From: info@sabdenparish.org.uk
Sent: 22 July 2019 21:46
To: planning
Subject: Application 3/2019/0446

Application 3/2019/0446

Construction of garage with parking for 5 vehicles to be used by Chapel House and Nos. 1 and 2 Chapel School. Installation of automatic gates, external lighting and CCTV; construction of garden summer house, greenhouse and patio area.

Gable Elevations

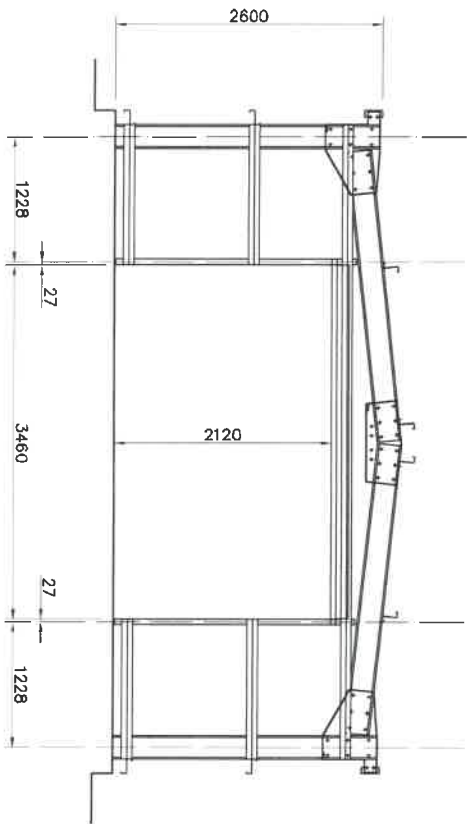
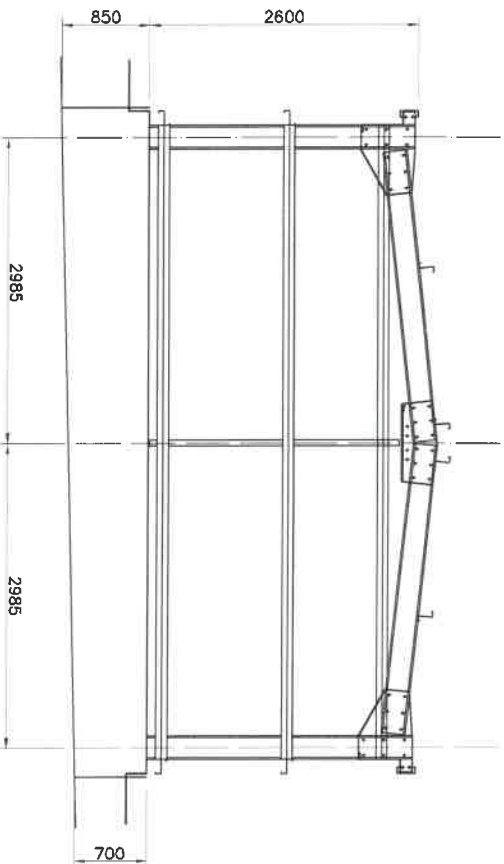
- The proposed materials are not in keeping with the AONB nor the surrounding area– (metal gives an industrial effect)
- The Height at the lower end – backing on to St Nicholas Mews- is high and would impose on the lower properties
- Concerns were expressed about future use of the building in view of the proposed size.
